84 Farragut St.
Road Extension
Archie Giobbi

**CITY OF PORTLAND, MAINE
DEVELOPMENT REVIEW APPLICATION
PLANNING DEPARTMENT PROCESSING FORM
Engineering Copy**

PUBLIC WORKS ENGINEERING REVIEW....3/18/03

I have reviewed the submittal dated 2/21/03 and offer the following comments:

Job No. 2763
 Sheet 1 of 3

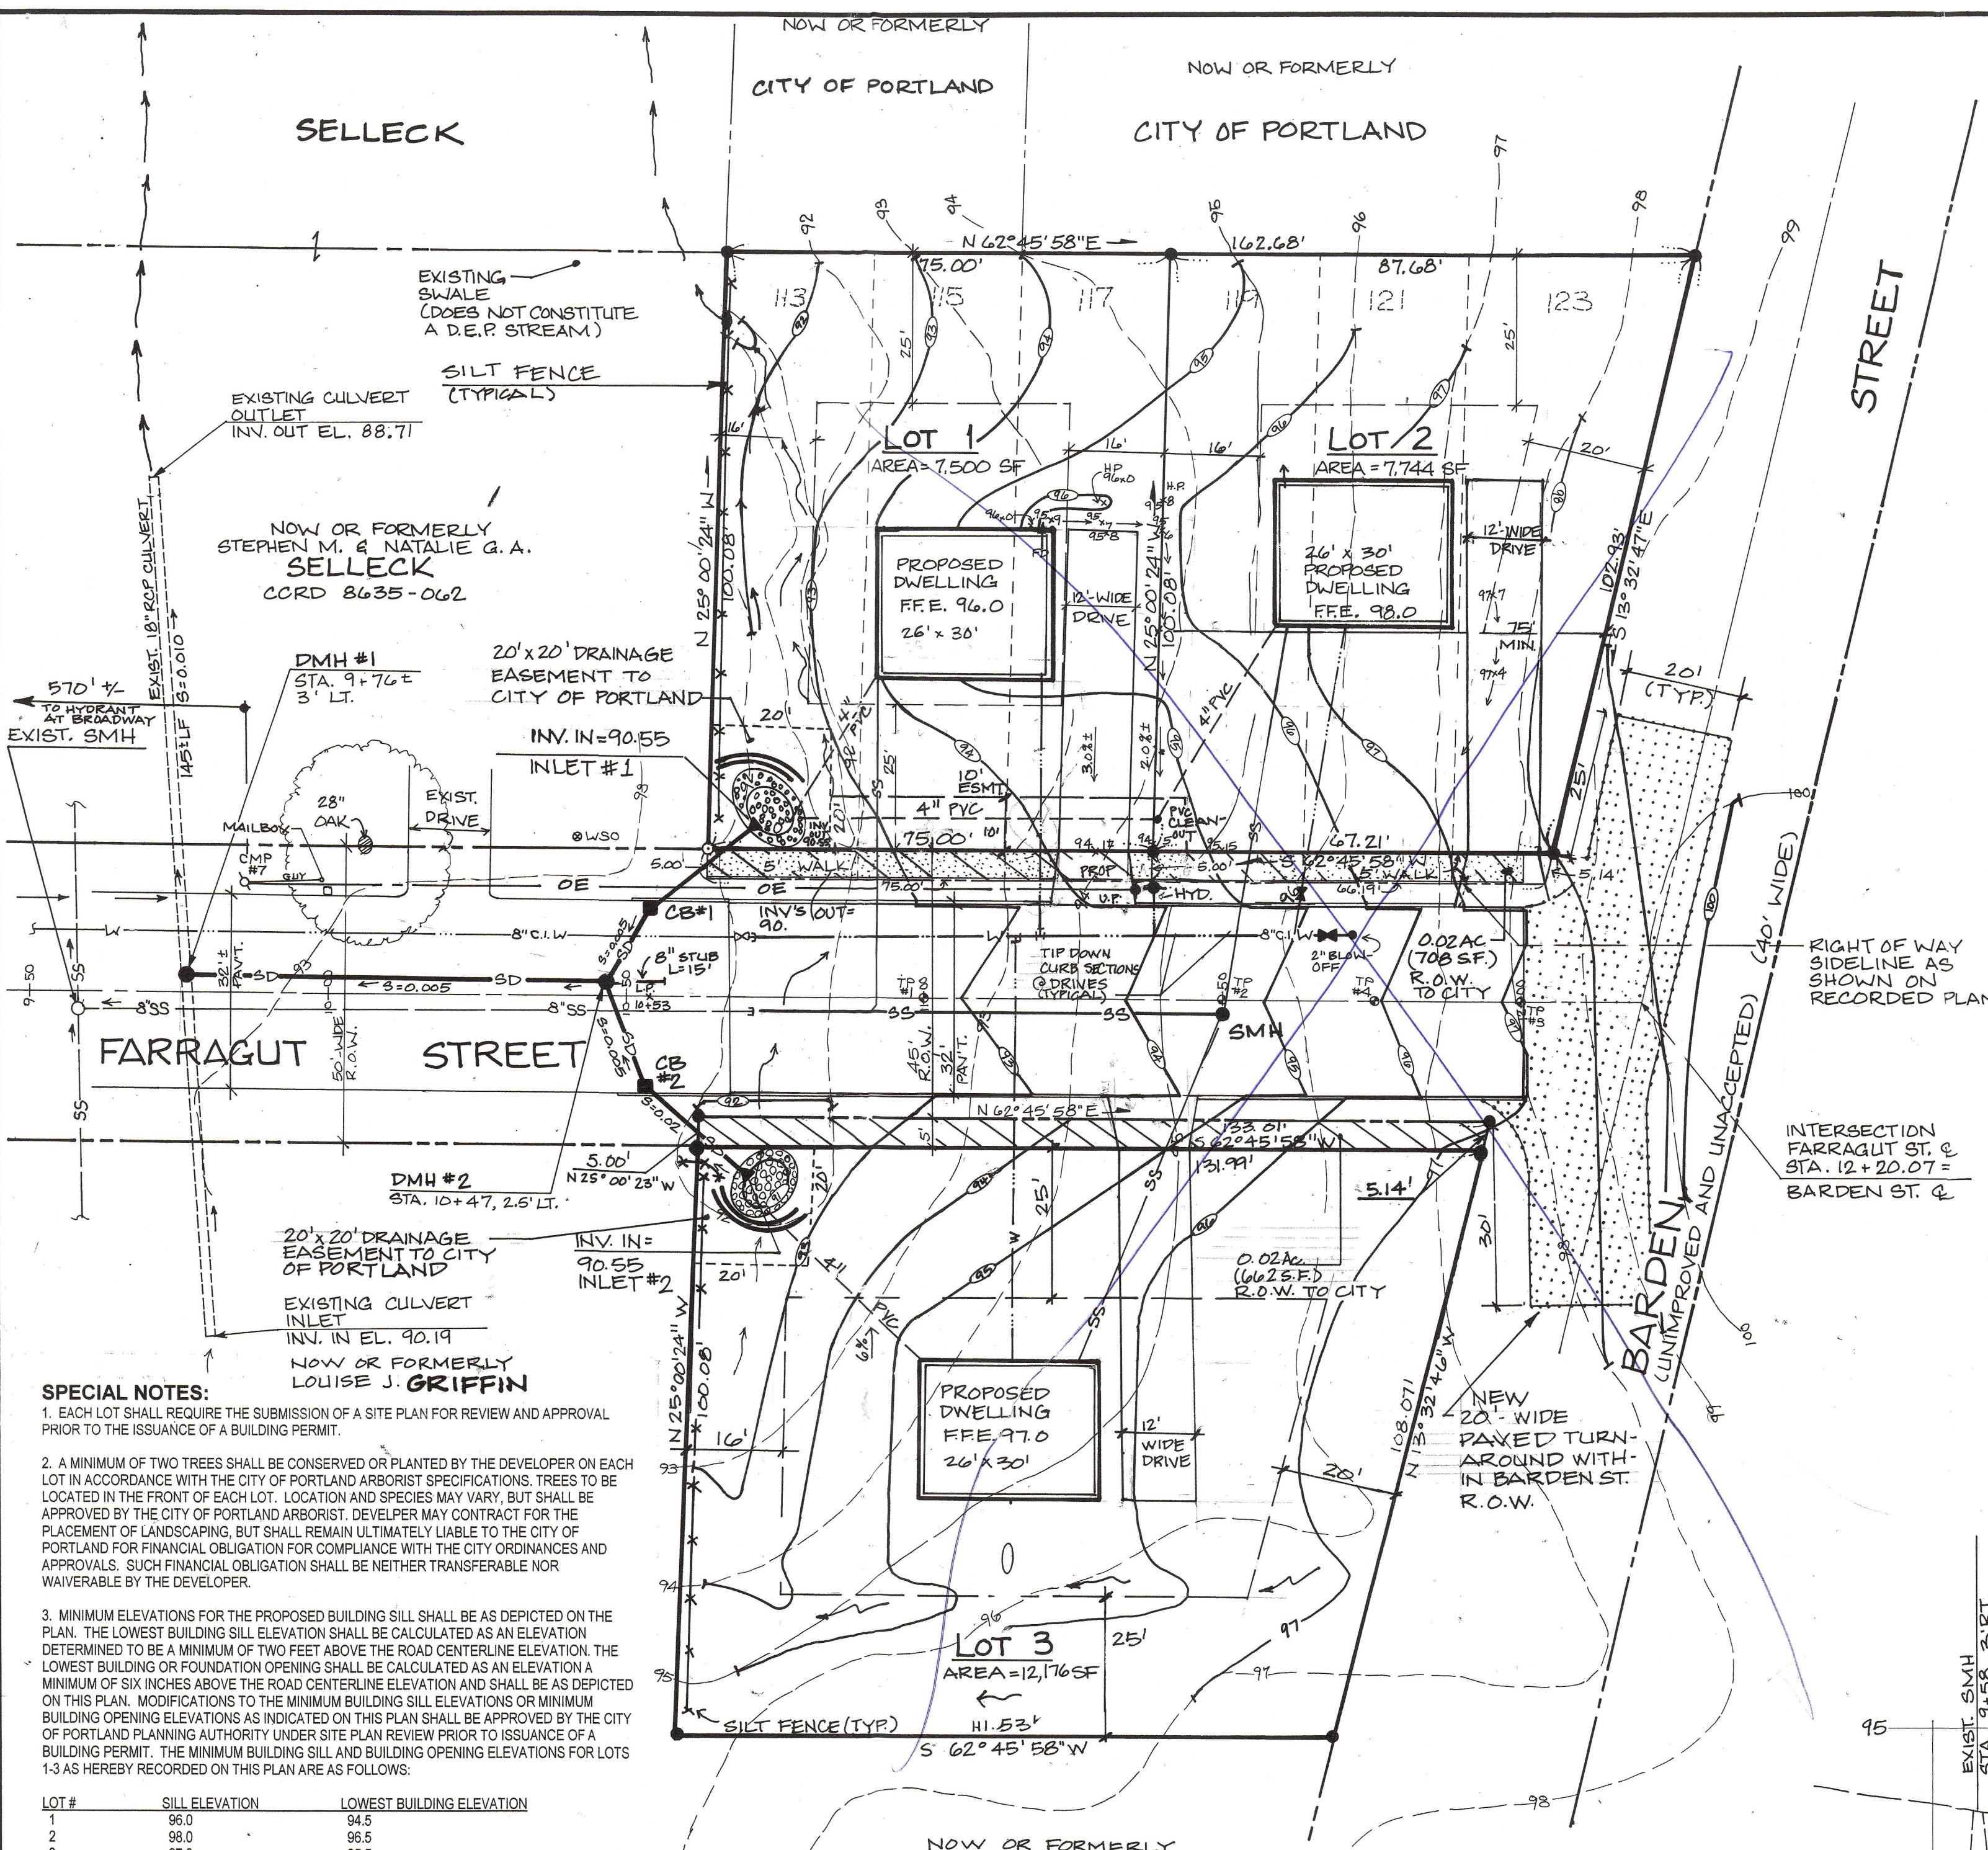
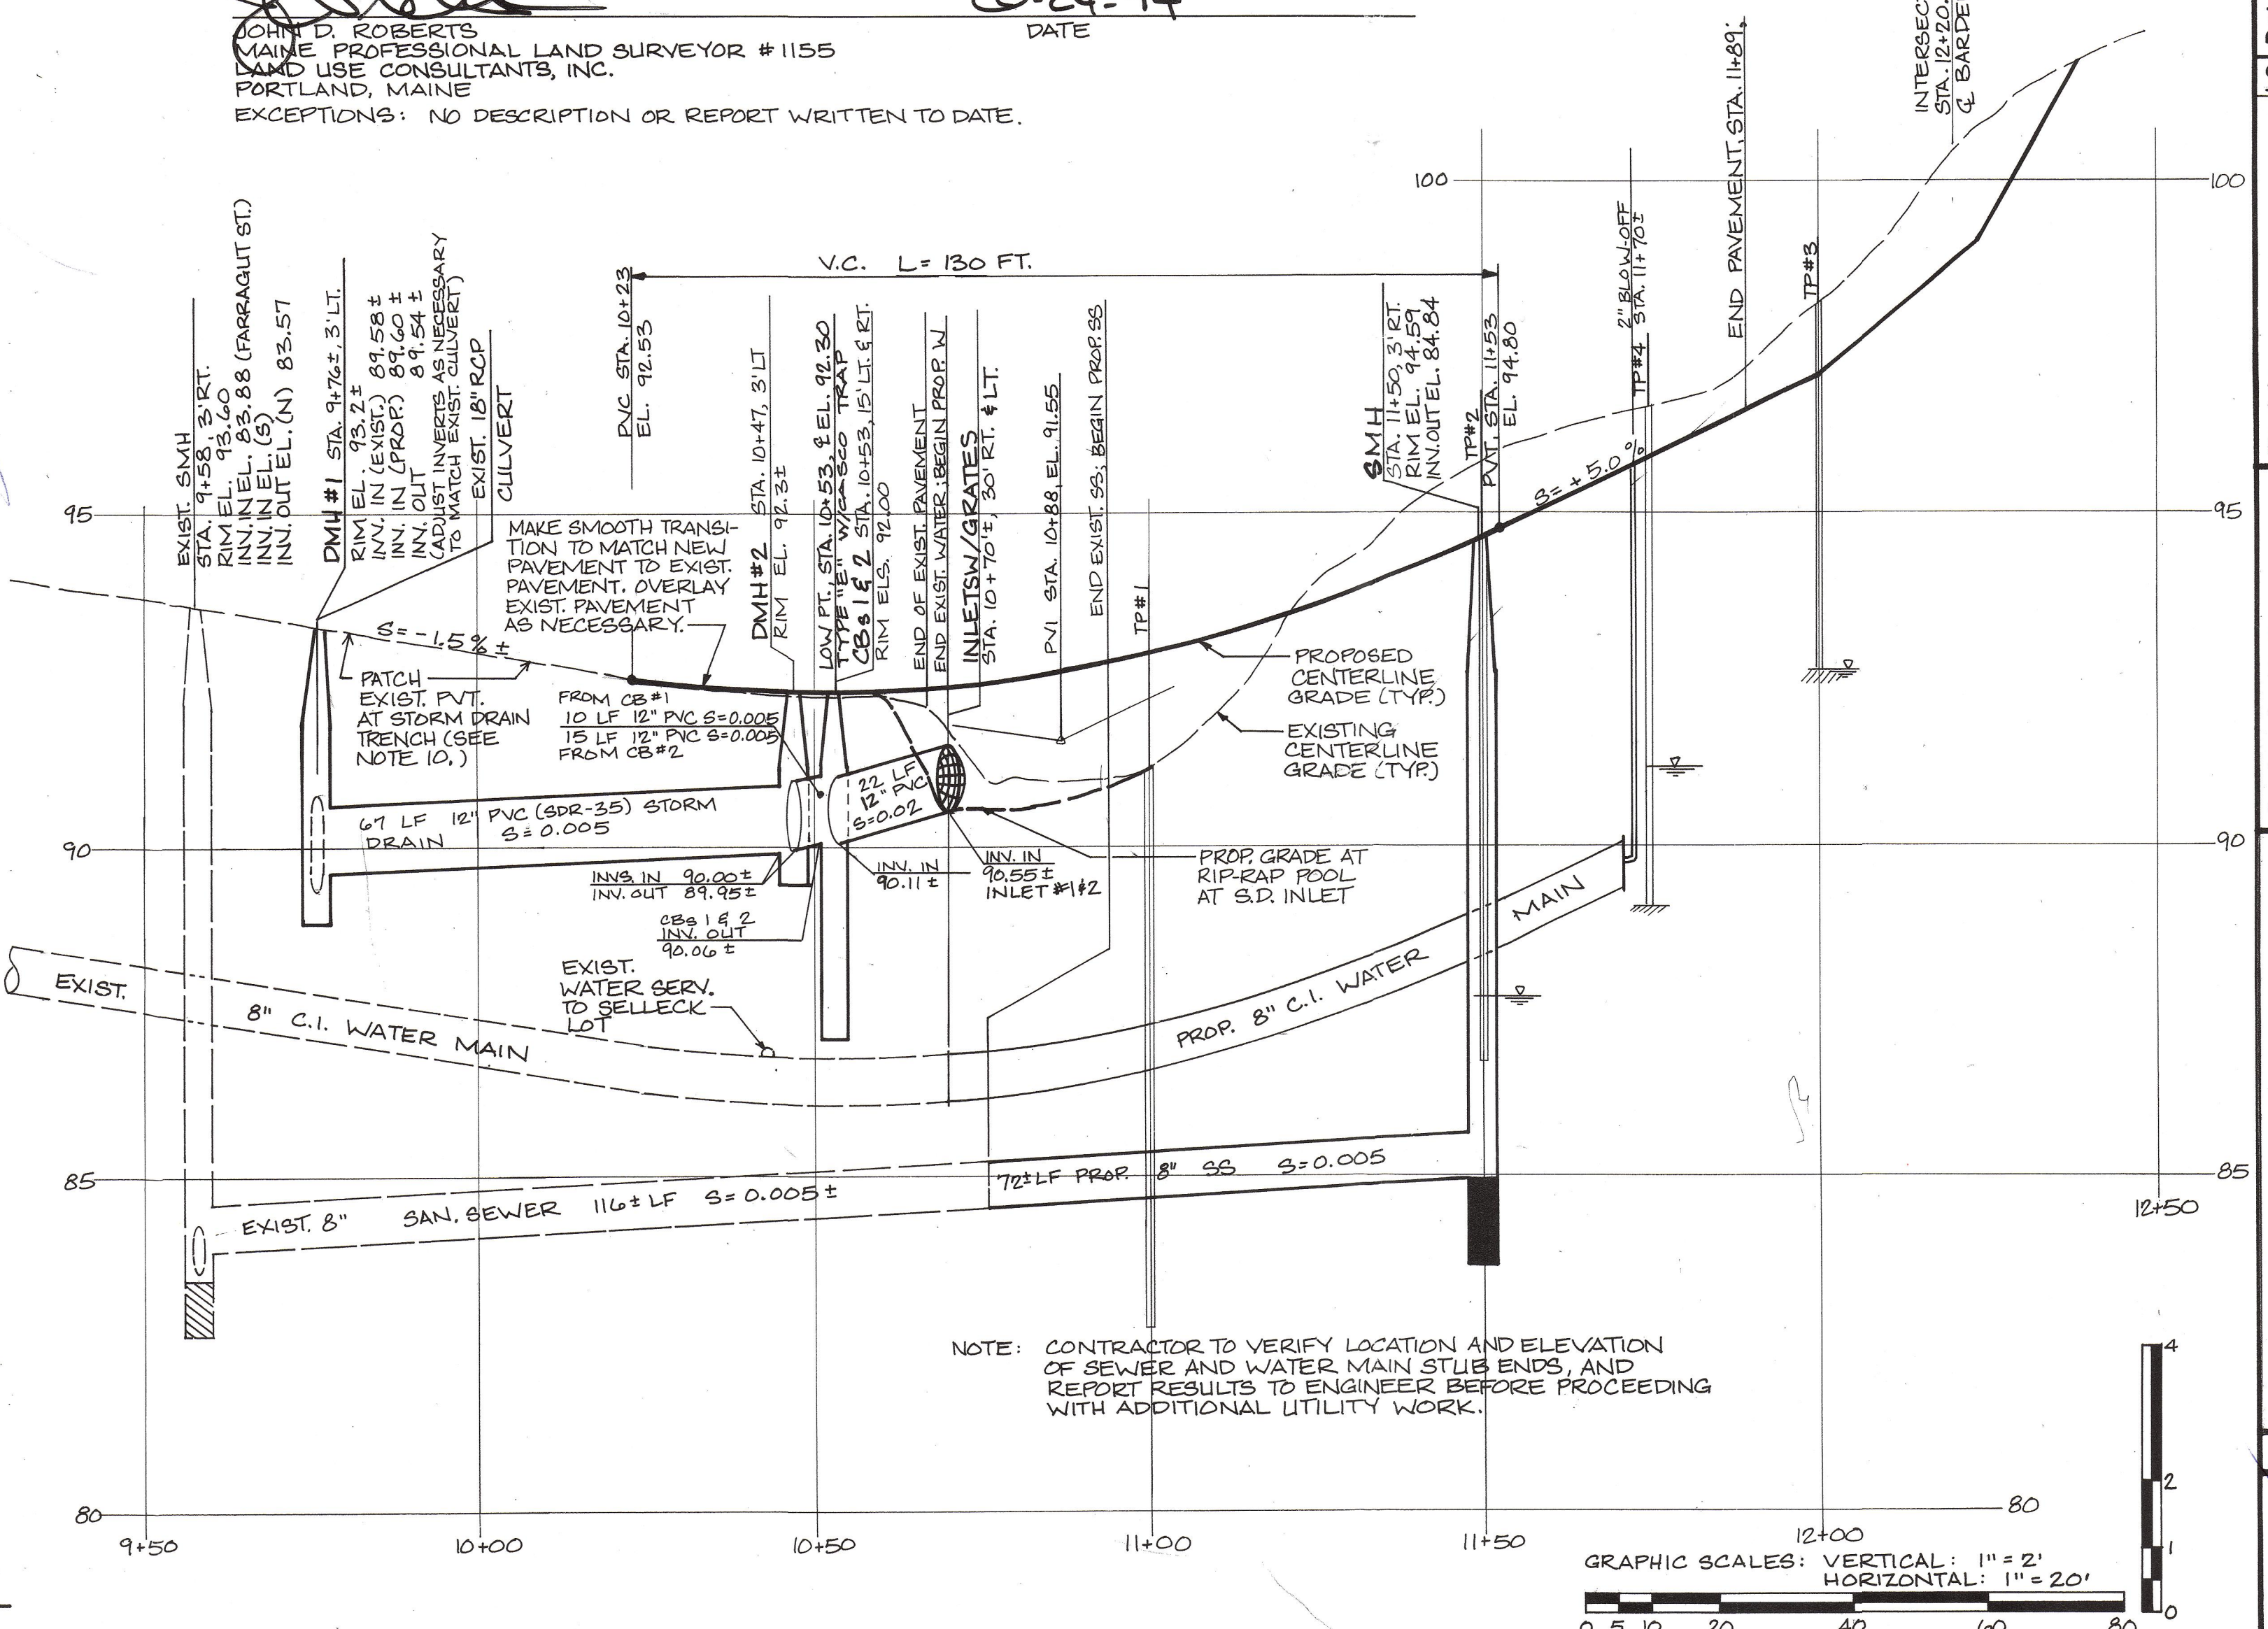
1. Upon reviewed the storm drain design, Public Works is requesting the applicant extend either a 6 inch or 8 inch diameter storm drain stub in an easterly direction towards Barden Street. The stub extending out of CB#1 should be approximately 85 linear feet. The stub extending out of CB#2 should be 35 linear feet. The purpose of these stubs would be to outlet foundation drains for the proposed dwellings.

3. It should be noted on the plans that both CB#1 and CB#2 will be fitted with the appropriately sized "casco" catch basin trap.
4. The proposed driveway entrances need to be revised to conform with the City's Technical Standard. The terminal ends of each driveway entrance should be 2 feet wider at the gutter line than at the property line.

14 TYPICAL INSTALLATION OF CURB
NOT TO SCALE

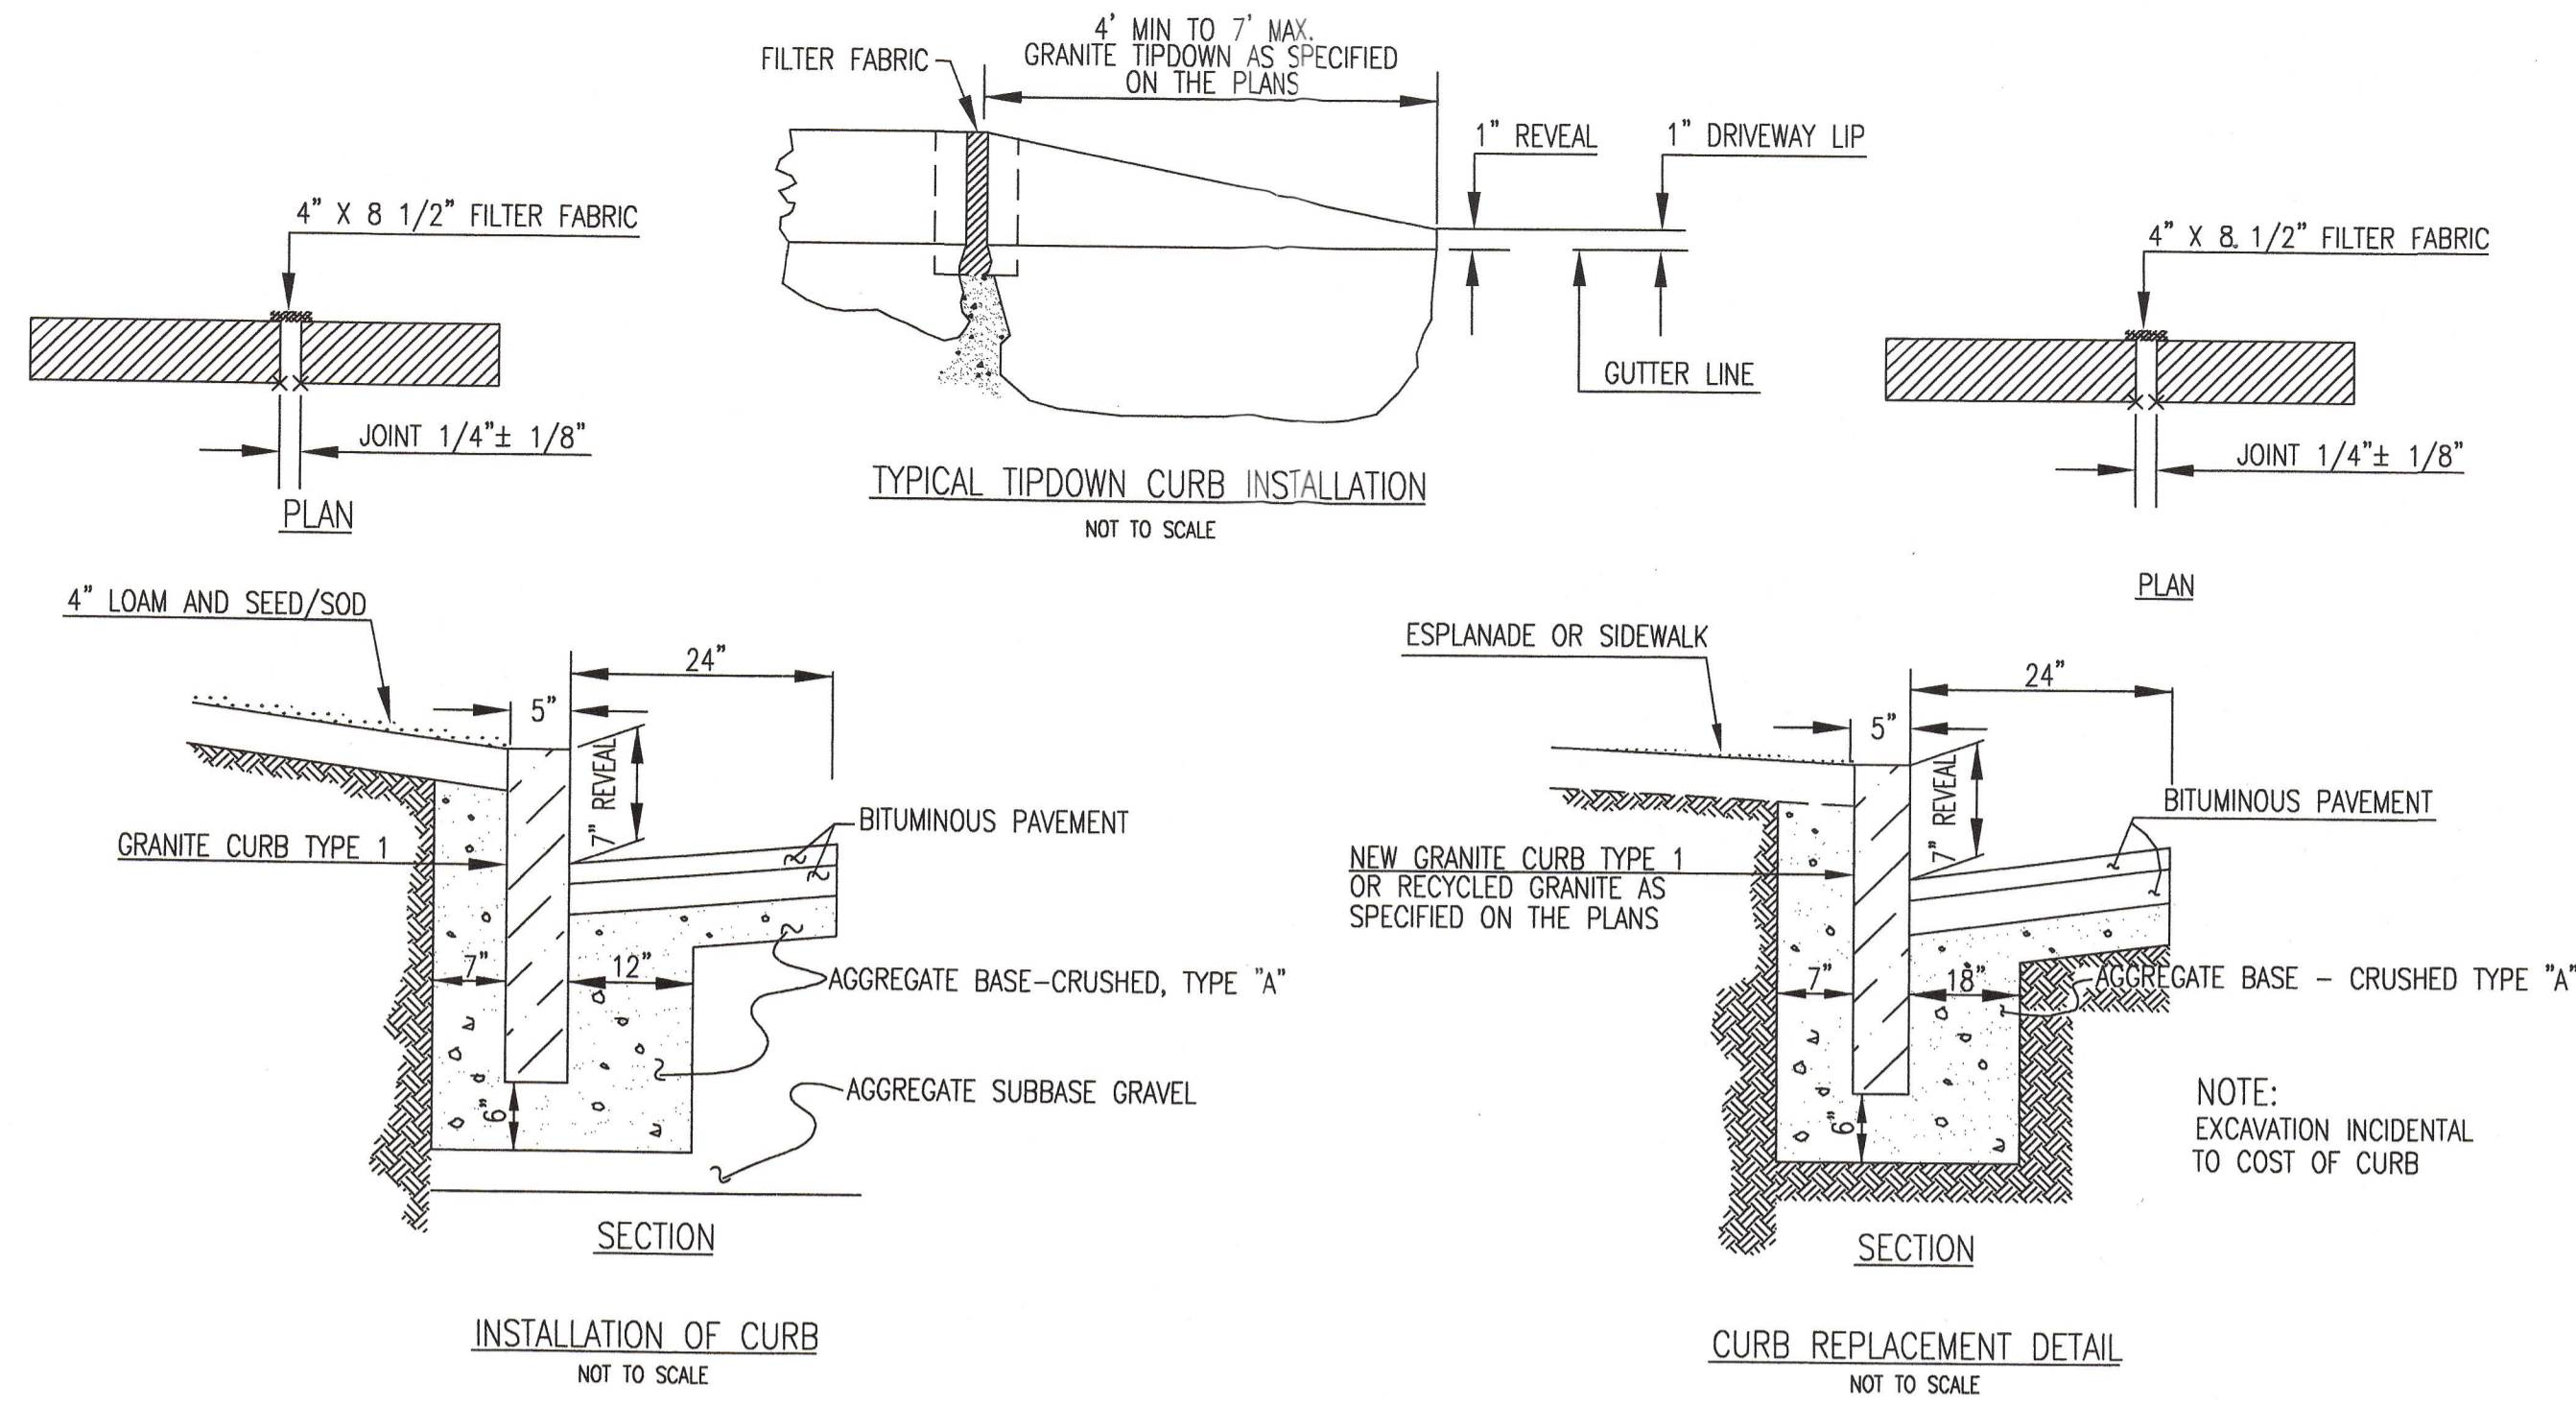
2. The plans need to specify details of the City's Technical Standard for a Type "E" catch basin structure; granite curb installation; "casco" trap for catch basin; driveway apron.
